From: adam kahan 
Sent: 19 September 2018 13:22
To: Zac Denton; Planning
Subject: R/188/18/HH objection

R/188/18/HH

I wish to object to this planning application because a) the application is factually incorrect both in the answers to questions on the form and the drawings submitted b) it breaches multiple Arun and Rustington policies.

EXISTING FLOOR PLANS, ELEVATIONS,
ROOF PLAN & LOCATION
81 Sea Avenue
Rustington
West Sussex
BN16 2DR

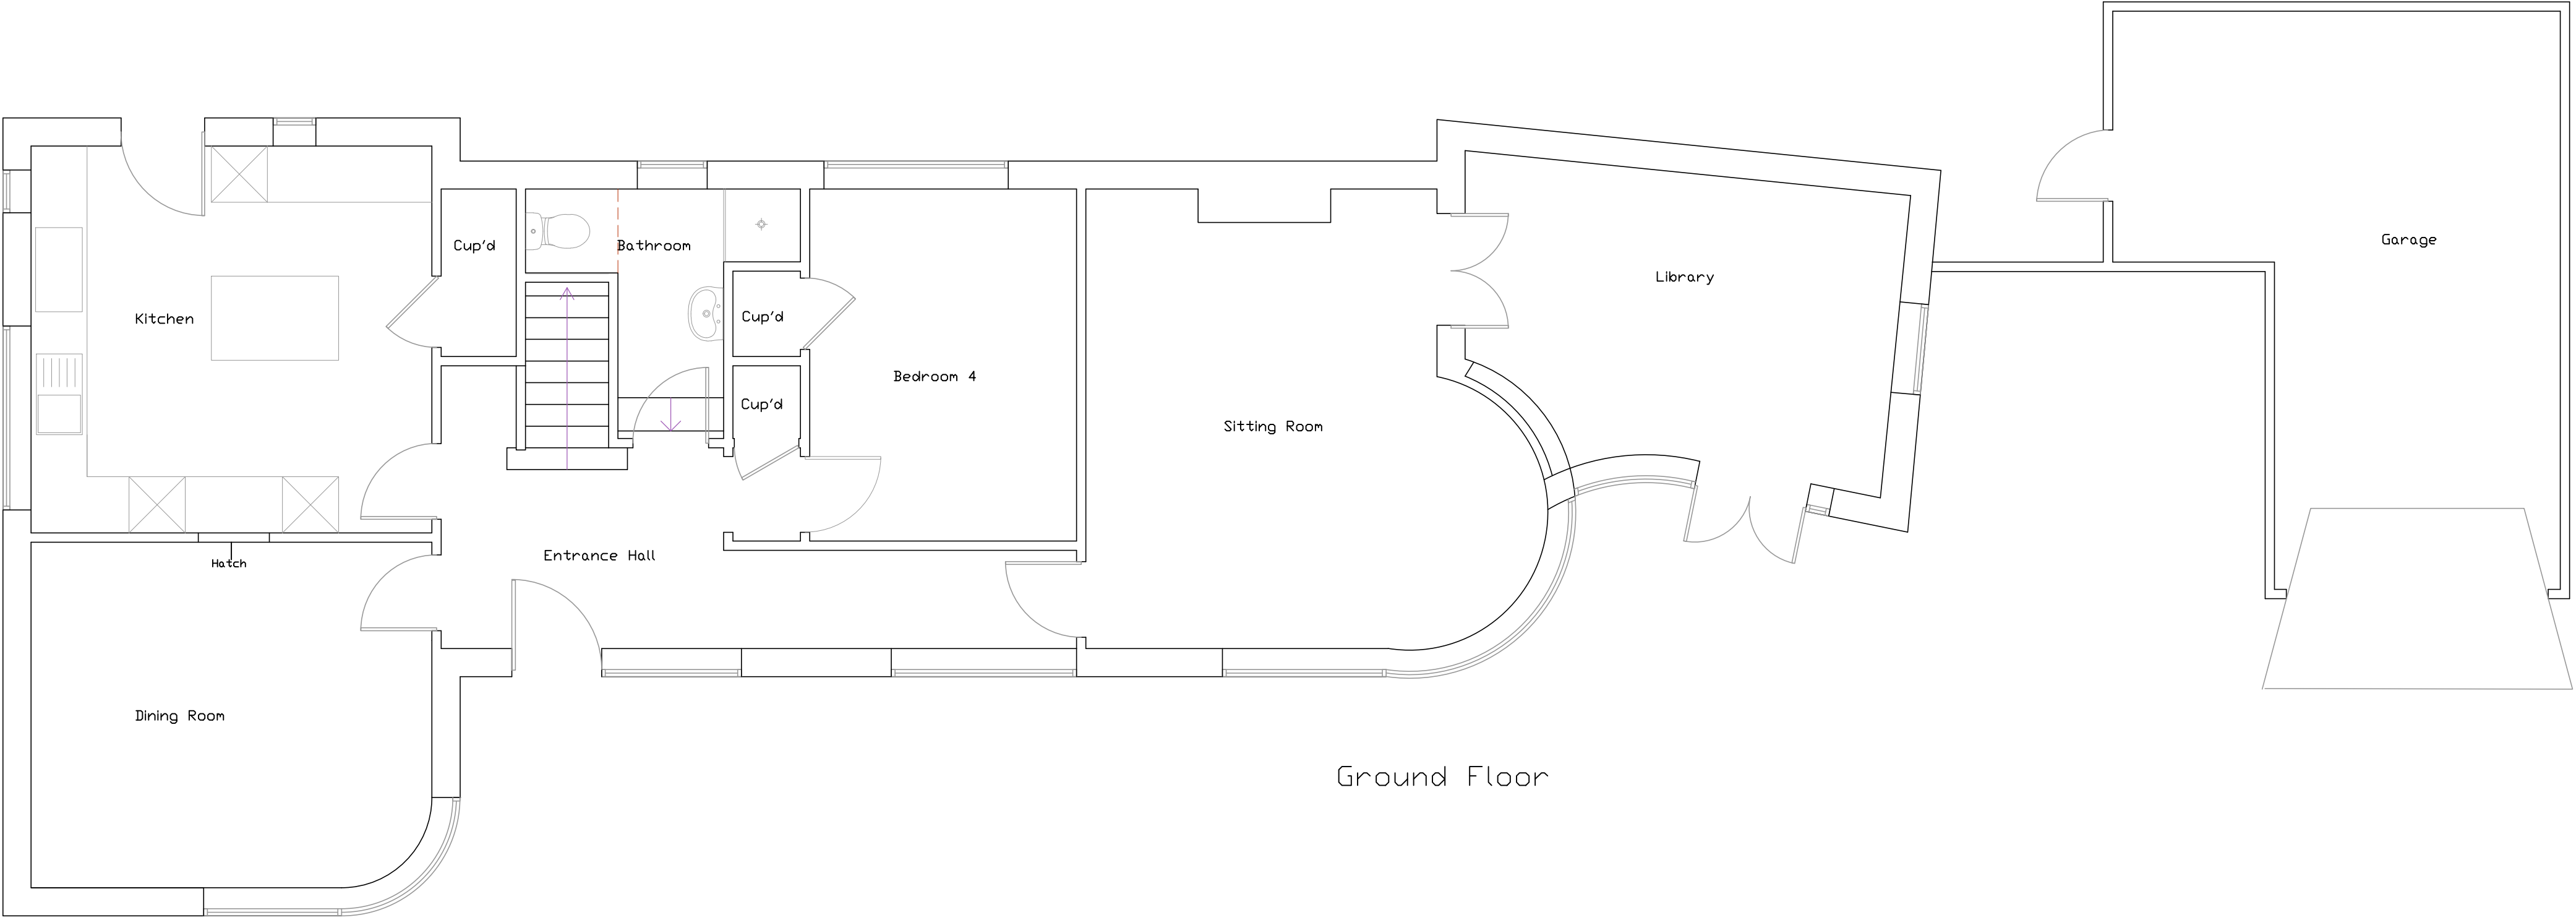
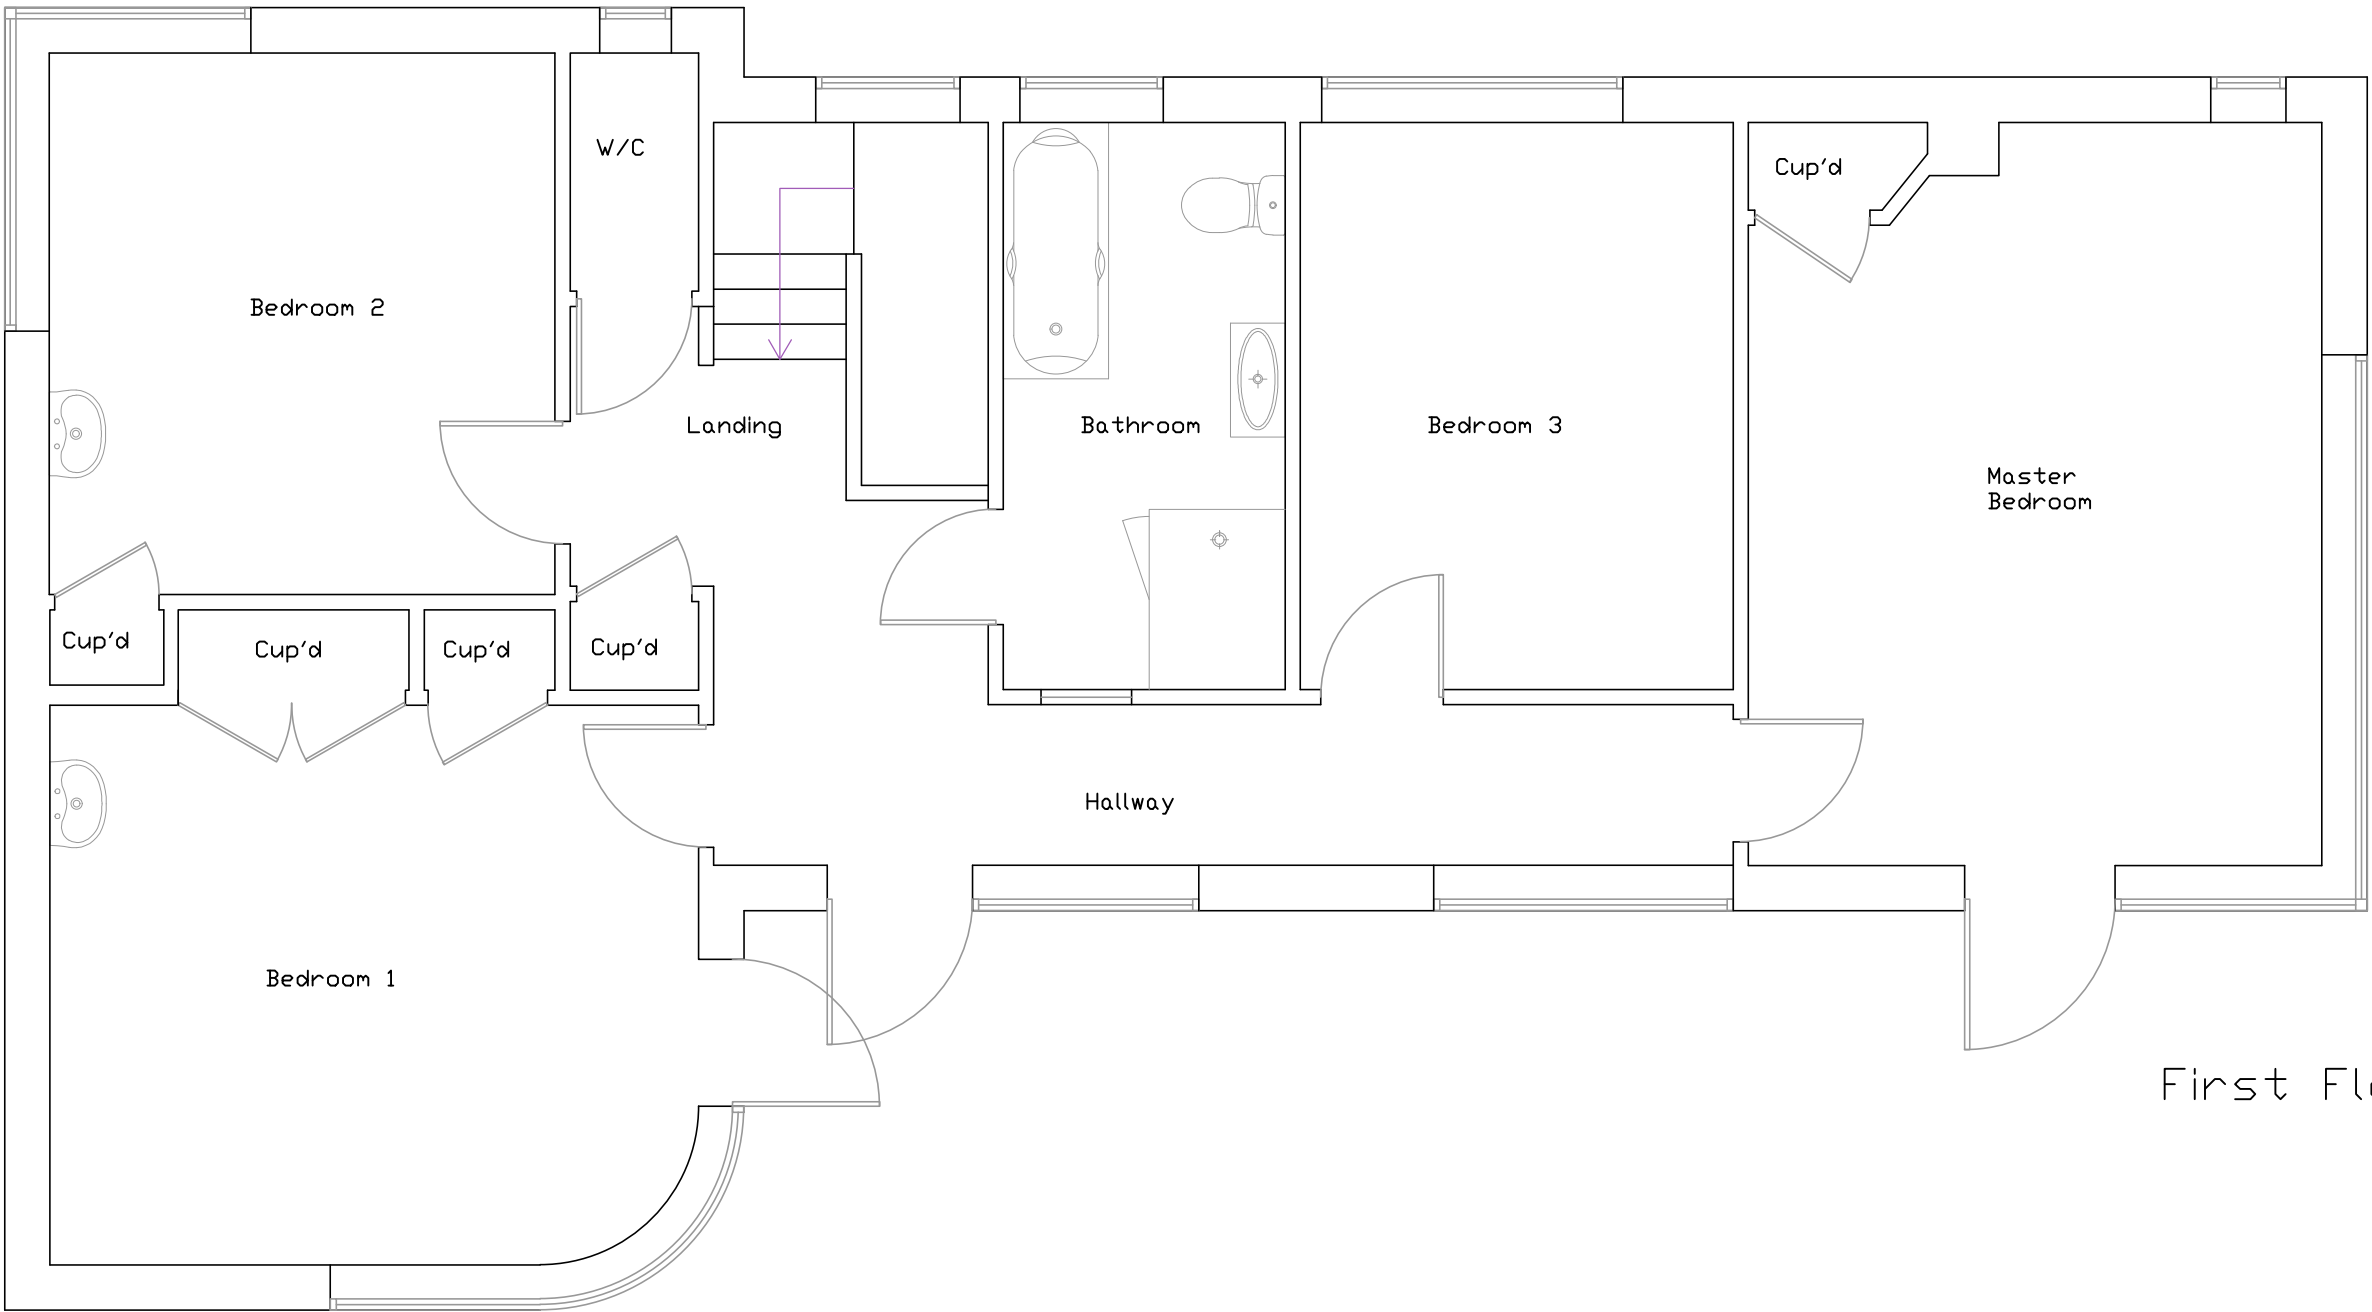
4. **INCORRECT DRAWING** The drawing of the existing building is incorrect. It fails to show that the applicants have already altered the kitchen including moving the external doors. They have converted the driveway north to The Thatchway into garden/recreation area.
